Item No. **Report of the Head of Planning, Transportation and Regeneration**

Address 58 BOLDMERE ROAD EASTCOTE

Development: Part two storey, part single storey side/rear extension, raising of ridge and conversion of roof space to habitable use to include a rear dormer and 2 side roof lights

LBH Ref Nos: **49427/APP/2019/1618**

PROPOSED FRONT ELEVATION - 1:100

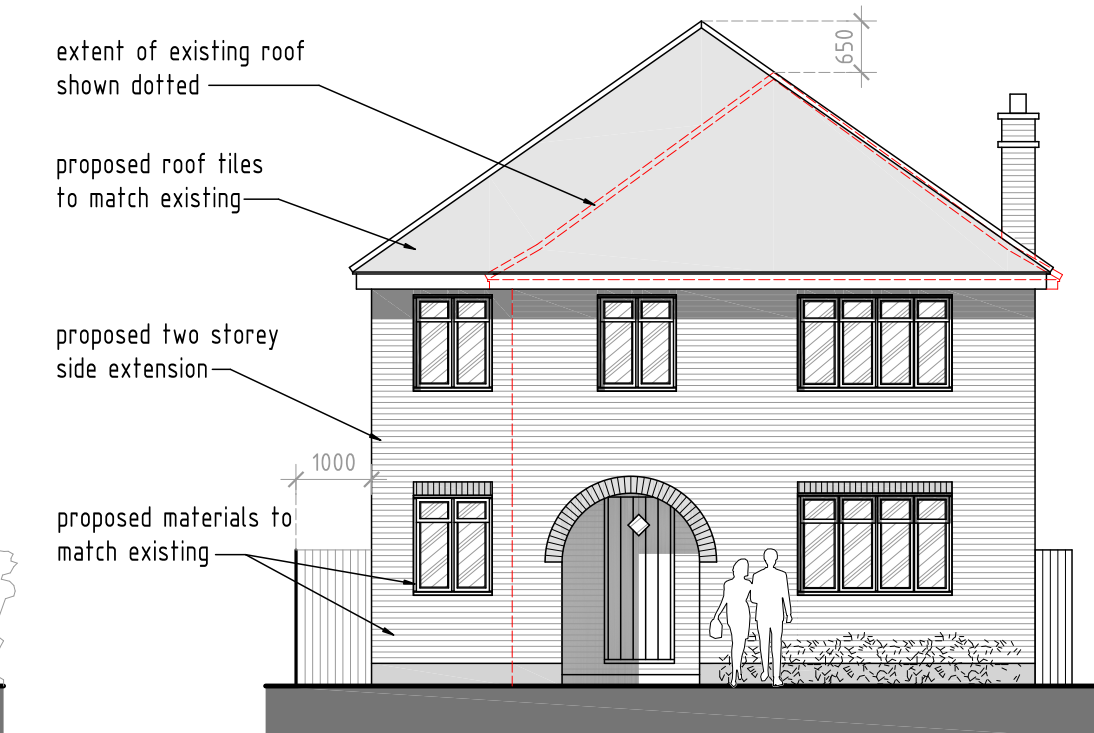
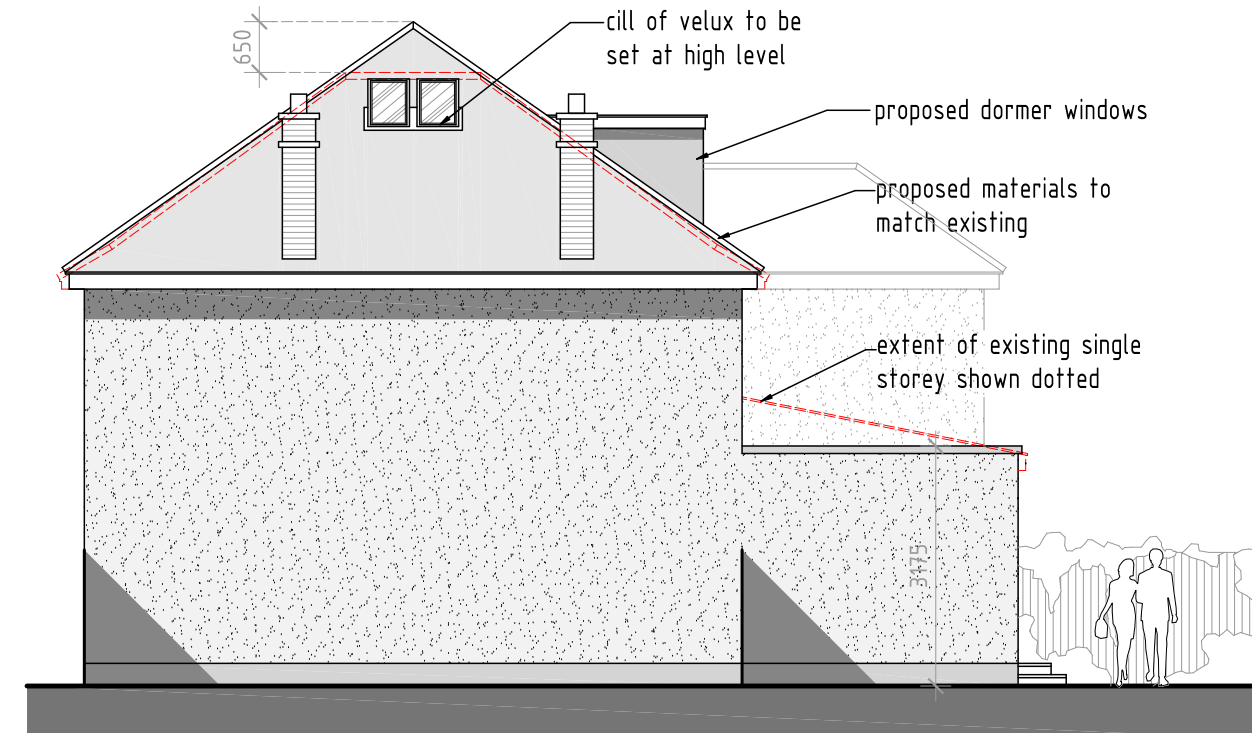
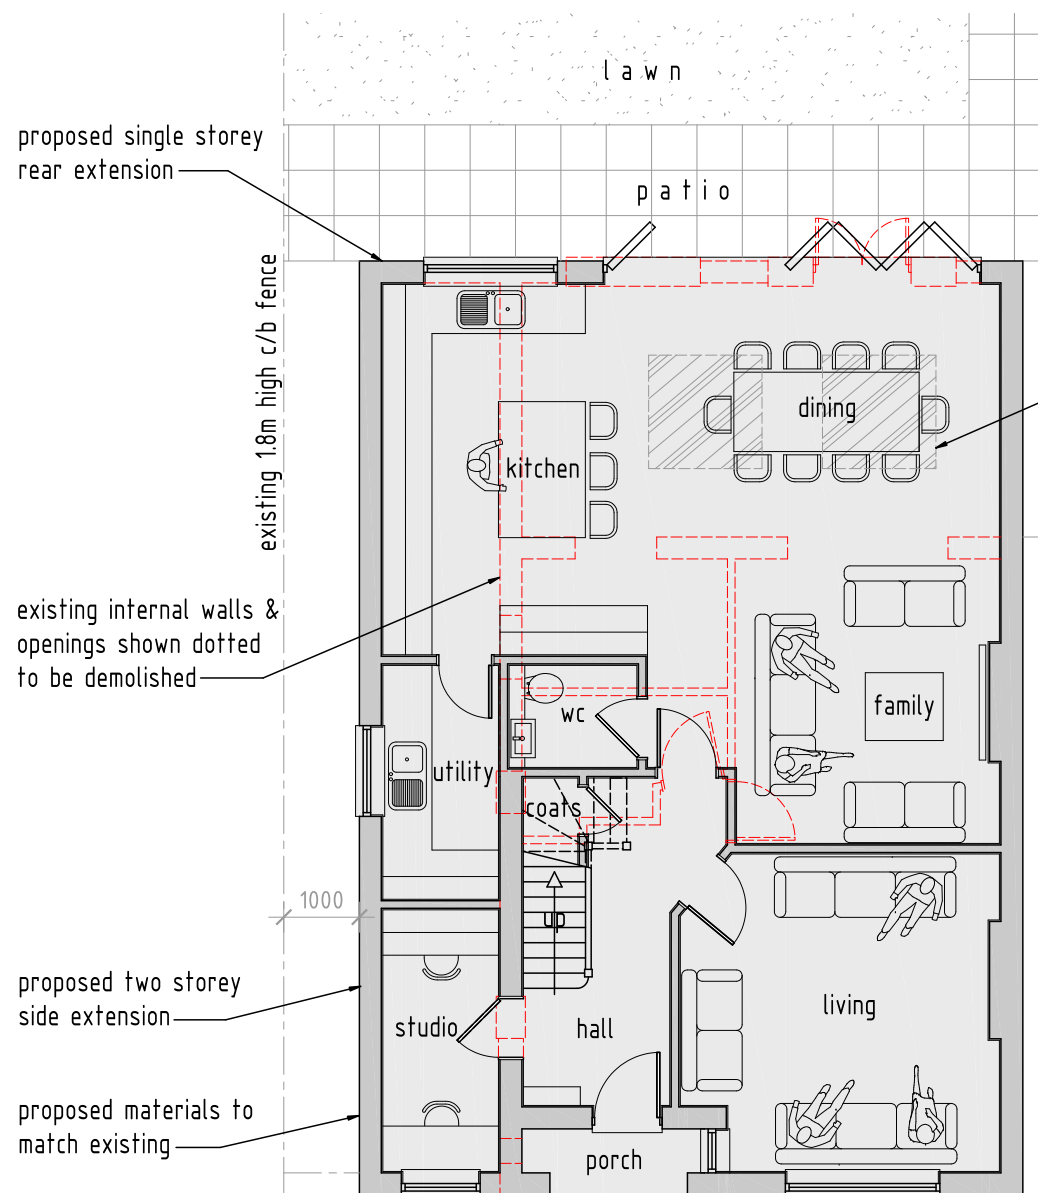
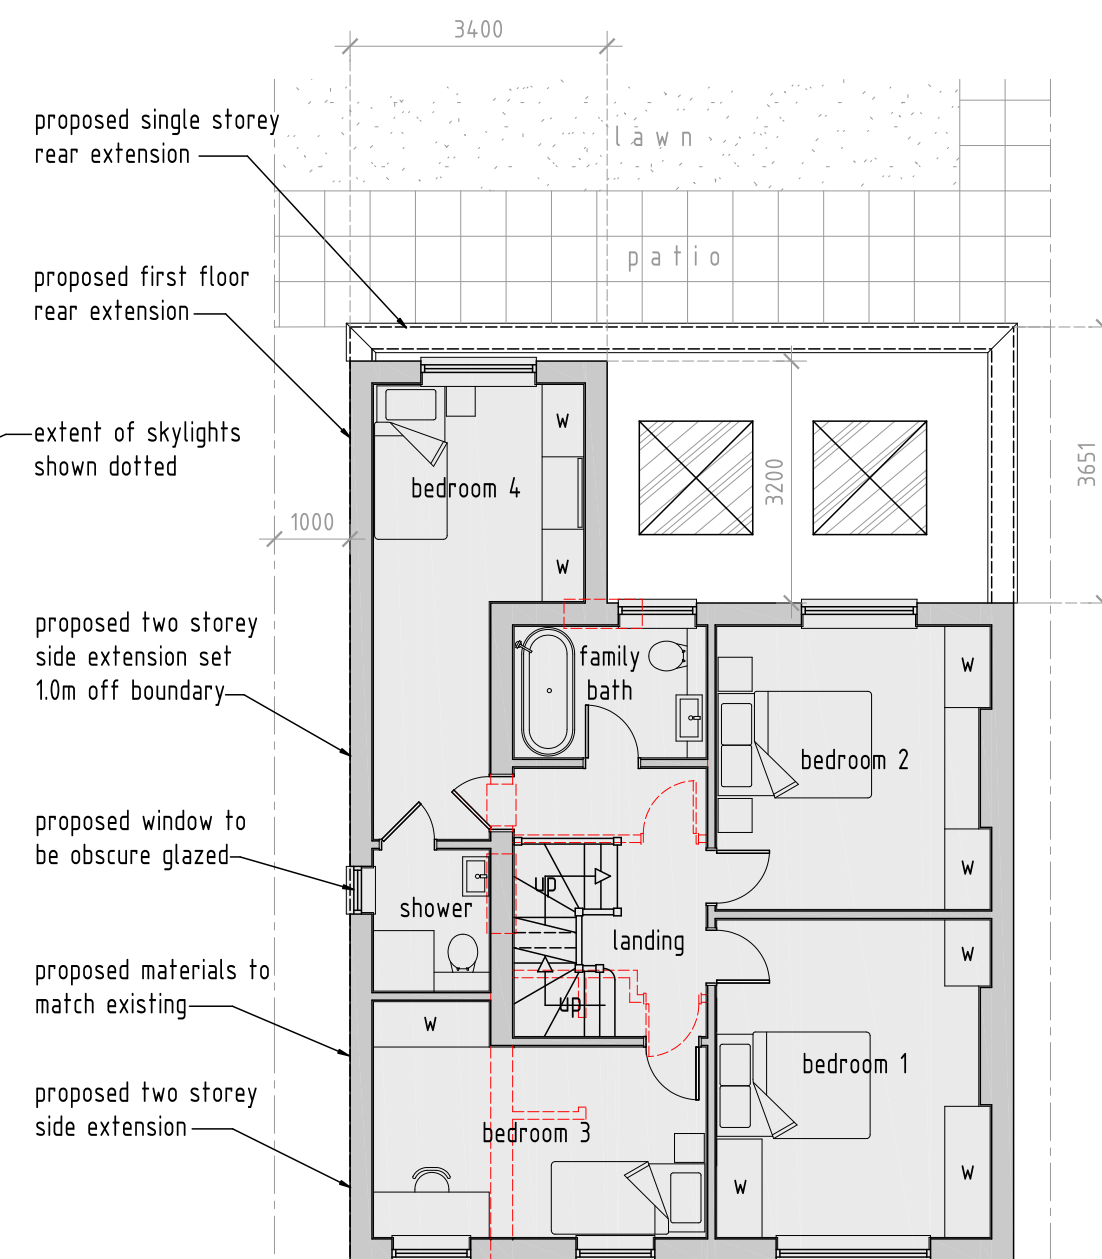
The side extension would have a width of 1.86 metres which would be approximately a quarter of the width of the original dwelling. The extension would be flush with the front elevation. The extension would be set in from boundary line by 1 metre in compliance with HDAS. However, although the extension would not result in the appearance of terracing, it is considered that its location on a corner plot would result in the loss of a visually open gap which is important within the heavily built up area.

In this particular case, the two storey side extension would unacceptably break the aforementioned building line to a greater extent than it does even now. Such development, which would be positioned close to the boundary with the pavement, would appear dominant and intrusive in the street-scene and would detract from the sense of open space which exists between the dwellings and the highway on this part of Chandos Road. The existence of the two storey side extension at No 60 is not considered to set a precedent for granting this proposal, which was agreed with by the Planning Inspector when reviewing the previous appeal. Indeed, if the proposal were to be granted it would have the effect of creating a visual pinch point when driving into Chandos Road. This would be an unacceptable impact detracting from the prevailing sense of open space that exists between the highway and most of the existing properties.

Subsequently, it is considered that by reason of the size, bulk, design and siting of the proposed two storey side extension the proposal would result in the closing of a visually open gap which would have a detrimental impact on the existing dwelling house and on the visual amenities of the street scene and surrounding area. Therefore, the proposal would fail to comply with Policies BE13, BE15 and BE19 of the Hillingdon Local Plan: Part Two - Saved UDP Policies (November 2012).

The proposed two storey side extension, by reason of its size, scale, bulk, depth, height, proximity to the side boundary and projection forward of the return building line along Chandos Road, in this open prominent position, would result in the closing of an important gap characteristic to the area, resulting in a cramped appearance. The proposal would therefore represent an overdevelopment of the site to the detriment of the visual amenities of the street scene and the character and appearance of the surrounding area. The proposed development is therefore contrary to Policy BE1 of the Hillingdon Local Plan: Part One - Strategic Policies (November 2012), Policies BE13, BE15 and BE19 of the Hillingdon Local Plan: Part Two - Saved UDP Policies (November 2012) and the Council's adopted Supplementary Planning Document HDAS: Residential Extensions.

At ground floor the rear extension would have a depth of 3.651 metres to match the existing extension. The proposed and existing ground floor extension would benefit from a flat roof with maximum height of 3.175 metres which would exceed HDAS recommendations. However, due to the limited depth it is considered that the additional height would be acceptable and it would appear subordinate. The first floor rear extension would have a depth of 3.2 metres and would be set down from the ridge by 1.8 metres which complies with HDAS recommendations.

The rear extension would be located 0.5 metres from the shared boundary with No.56 Boldmere Road, however, the extension would not exceed the depth of the existing extension and the maximum height would be reduced. The first floor extension would be located 5.9 metres from the shared boundary line and would not intersect the 45 degree horizontal line and the dormer would not project to the rear of the existing roof plane. It is considered that No.60 Boldmere Road and No.26 Chandos Road are located a sufficient distance away to ensure that the extension would not have a detrimental impact on these neighbouring properties. Two side windows would be installed facing Chandos Road, however, both serve non-habitable rooms bathrooms and so a condition could be added to ensure that these are obscure glazed. The first floor rear extension would benefit from a new window facing No.26 Chandos Road, however this would overlook the flank wall and front garden of the property. Subsequently, it is considered that the proposal would not have a detrimental impact on any neighbouring property in terms of loss of light, loss of outlook, loss of privacy and sense of dominance and therefore would comply with Policies BE20, BE21 and BE24 of the Hillingdon Local Plan: Part Two - Saved UDP Policies (November 2012).

PROPOSED ROOF AREA PLAN - 1:100

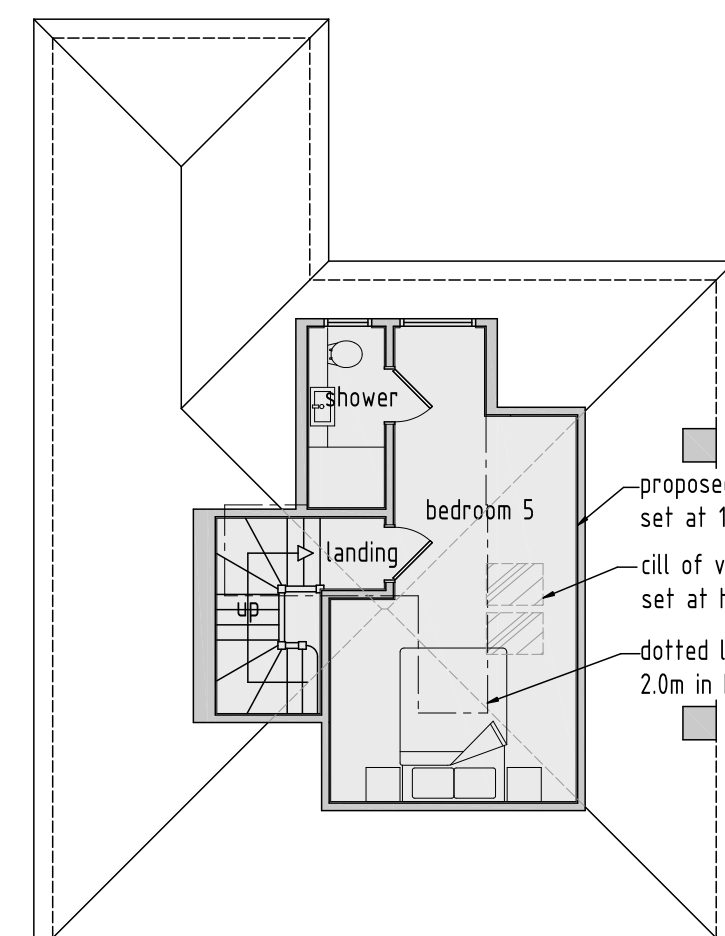
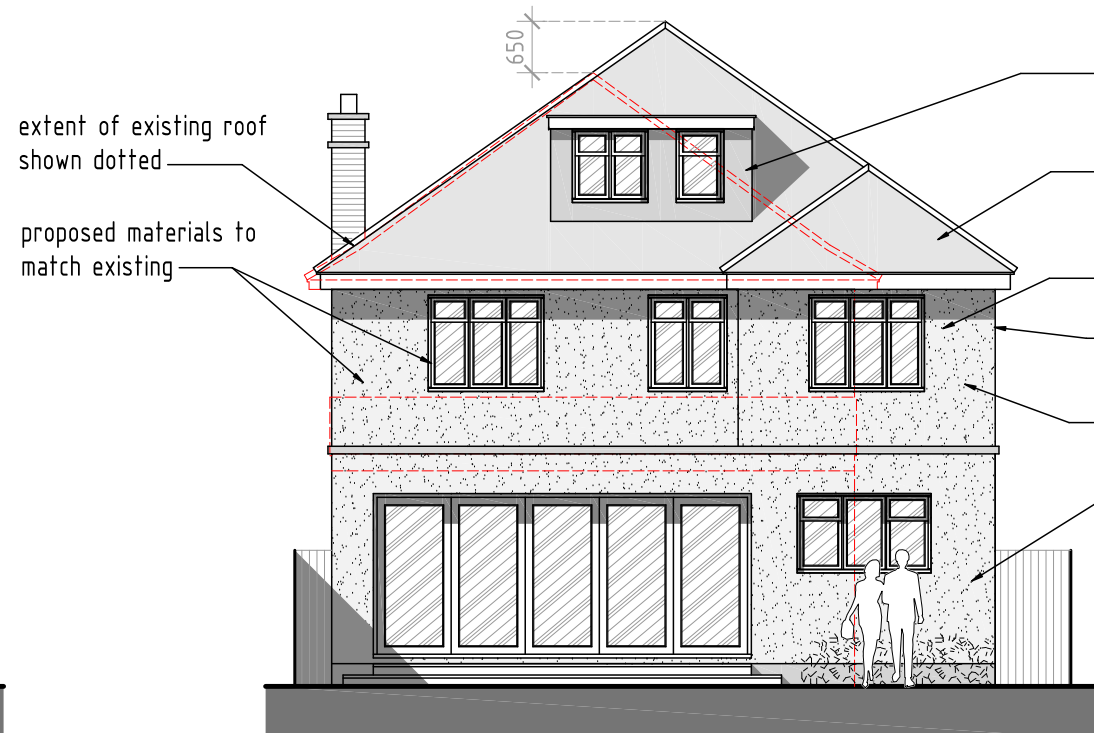
The height of the side extension would exceed the height of the existing ridge, however it would form part of the enlargement of the roof aspect of this proposal. The roof would be raised by 0.65 metres to a maximum height of 8.8 metres. The neighbouring semi-detached properties at Nos.54 and 56 Boldmere Road benefit from a higher ridge height than the existing application property and so it is considered that the raising of the ridge would allow No.58 to be of a similar height to these neighbouring properties and so it would not appear out of keeping with the street scene. The proposed dormer would be located centrally within the roof plane and would be located 1 metre from the eaves and over 1 metre from the sides and new ridge. It is considered that it would appear subordinate within the roof plane and would not create the appearance of a flat roofed third storey.
